To: Planning **Subject:** 3/2024/0218

Following consultation with members of the Parish Council, the following concerns have been lodged:-

Client: Mr Stones			
Project: Proposed Alterations 3 Springdale Road Langho			
Dwg title: Proposed Rear Elevation			
Scale @ A4: 1:50	Date: 20.02.24	Drawn by: PD	
Drawing no. 1563 - 11			Rev. -

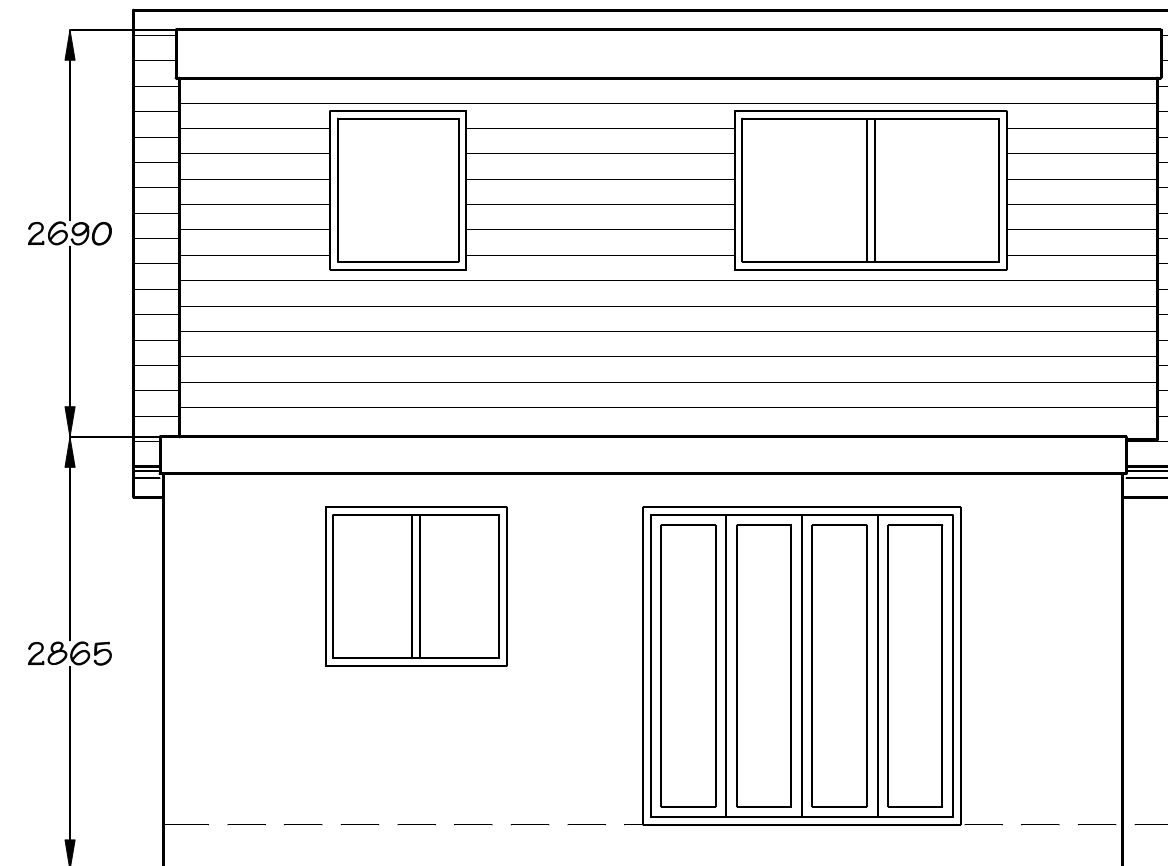
- 1 Concern that the proposed rear extension may be too large and impose on the next-door neighbour. To this end please would the planning office to check whether the extension does impinge too much on the next-door neighbour's property?
- 2. According to the planning design statement the rear dormer and extension are covered by permitted development and the front dormer is the only part of the conversion that needs planning permission, there is also at least one objection about the rear extension not being in keeping with the area, the parish council requests that Planning take this on board.
- 3 tThe parish council requests that r a planning officer to visit the property, if they haven't done so already to see if any planning breaches have already occurred,
